From: [AUSLAND, BART \(DNR\)](#)
To: [Jeff Watson](#)
Cc: [Vic Monahan](#)
Subject: Moratorium Question
Date: Wednesday, September 29, 2010 1:01:13 PM

MEMORANDUM

TO: Trudie Pettit, Community Development Services
FROM: Christina Wollman, Planner II *CW*
DATE: September 12, 2008
SUBJECT: Monahan Mountain Forest Tracts Large Lot Subdivision LL-08-04

RE: Monahan Mountain Tree Farm Tracts Large Lot, LL-08-05
Monahan Mountain Forest Tracts Large Lot, LL-08-04

Kittitas Co. Large Lot Subdivision NO. 08-04
 Portion of Section 14, Twp. 20N., Rge. 13E., W.M.
 Kittitas County, Washington

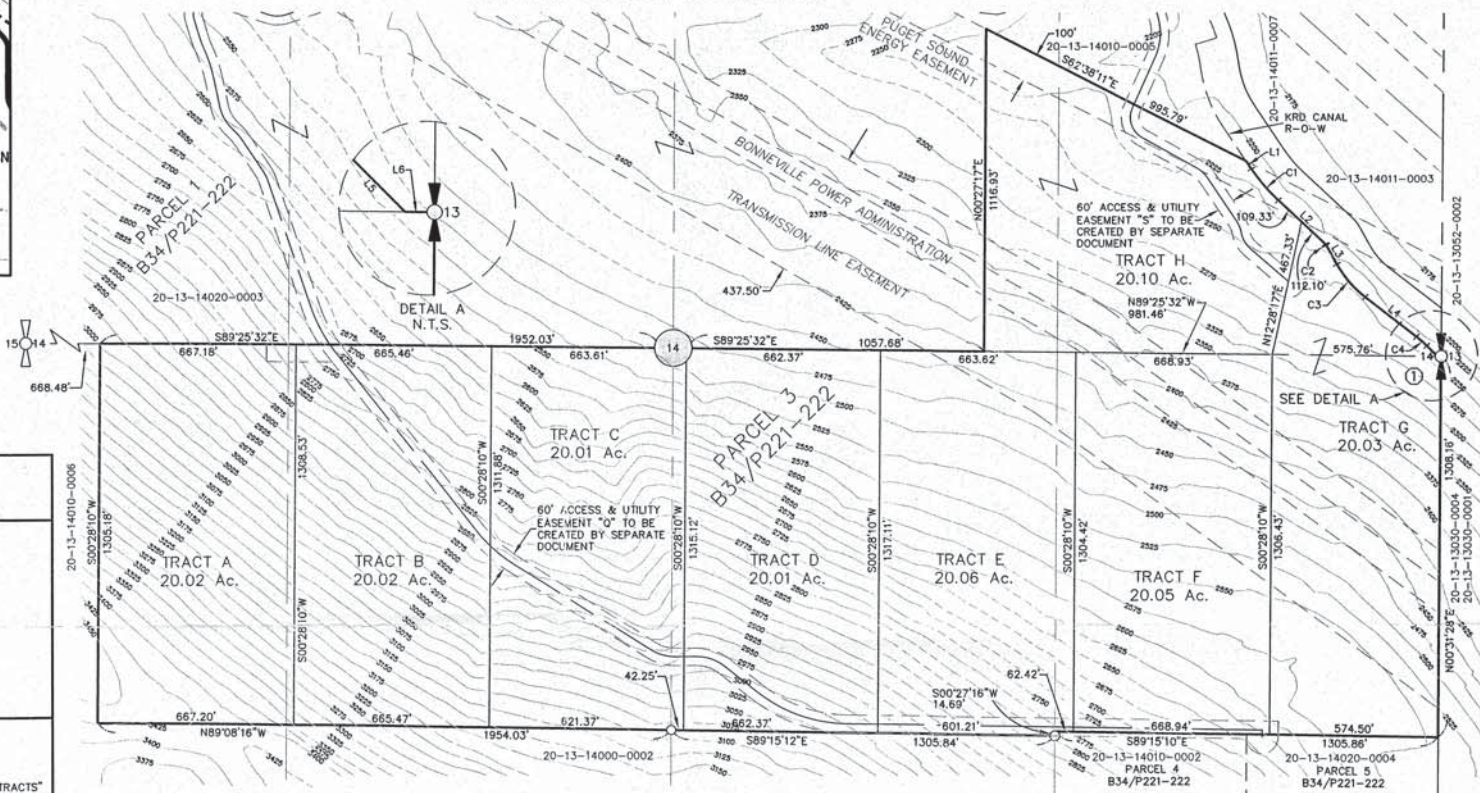
2. **Site Distance:** The access with Cabin Creek Road shall be improved to meet site distance if necessary. Site distance shall be included in the road certification

3. **Access Easements:** All access easements shall be recorded prior to final approval.
4. **BPA and PSE Easements:** The applicant shall submit an agreement or other documentation from BPA and PSE allowing access across the powerline easements.

5. **Tract A Access:** The easement to Tract A shall be described on the final plat.
6. **Certificate of Title:** The certificate of title shall be submitted prior to receiving final approval.

7. **Private Road Improvements:** Access from Cabin Creek Road to the cul-de-sacs shall be constructed as a Low-Density Private Road. See Kittitas County Road Standards, 9/6/05 edition.

- a. Access easements shall be a minimum of 60' wide. The roadway shall have a minimum width of 20', with 1' shoulders, for a total width of 22'.
 - b. Minimum centerline radius will be 60'.

8. Cul-de-Sac: A cul-de-sac turn-around having an outside right-of-way easement diameter of at least 110 feet shall be constructed at the closed end of all dead-end roads serving 3 or more lots. The driving surface shall be at least 96 feet in diameter. Cul-de-sacs must also conform to the requirements specified by the 2006 International Fire Code. Contact the Fire Marshal regarding any additional cul-de-sac requirements.

Kittitas Co. Large Lot Subdivision NO. 08-XX		
Portion of Section 14, Twp. 20N., Rge. 13E., W.M.		
Kittitas County, Washington		
DWN BY G. WEISER	DATE 04/08	JOB NO. 05502-4
CHKD BY D. NELSON	SCALE 1"=300'	SHEET 1 OF 2

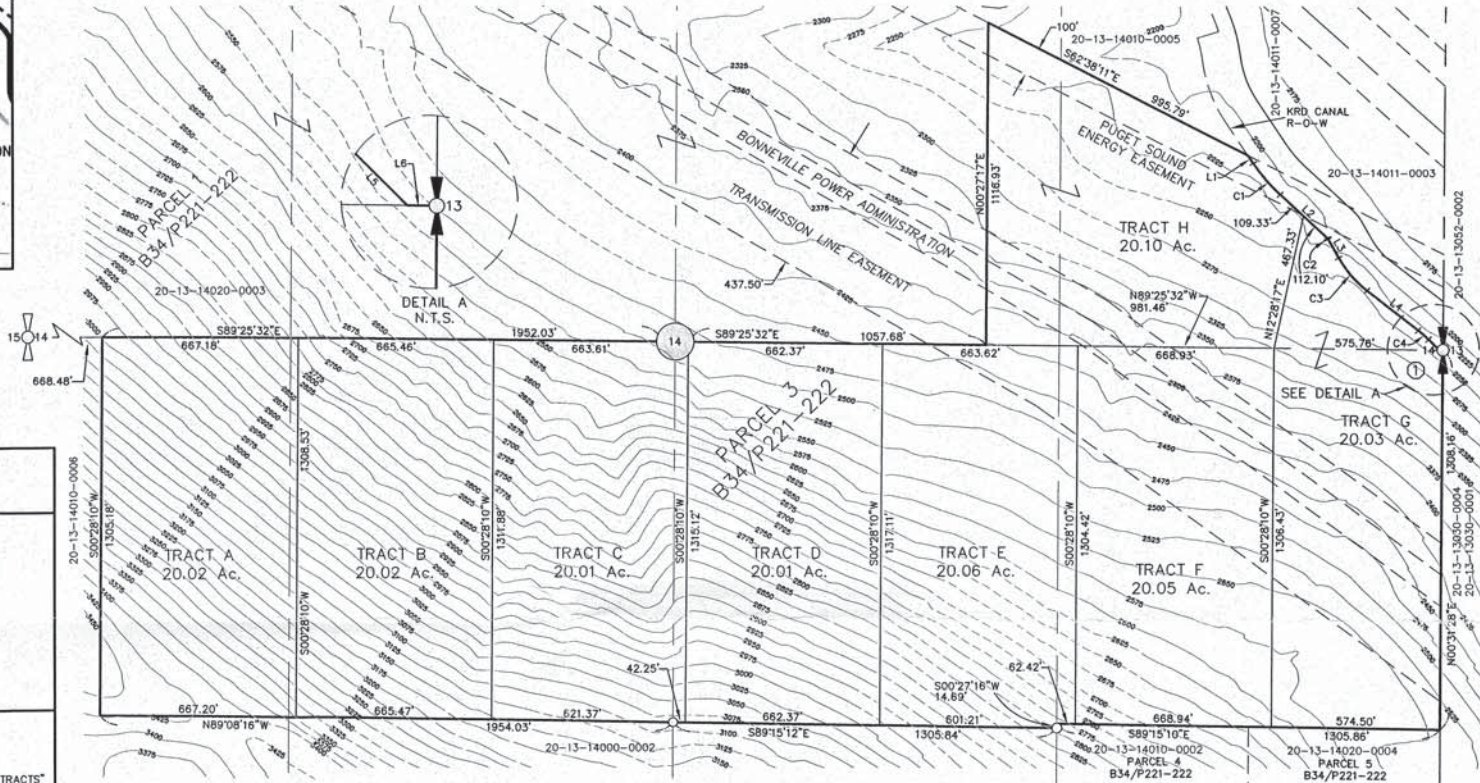
1. Access: The proposed Large Lot Subdivision does not appear to depict any access easement on their application. In order to review the application, the access to all lots shall be clearly depicted on the face of the plat.
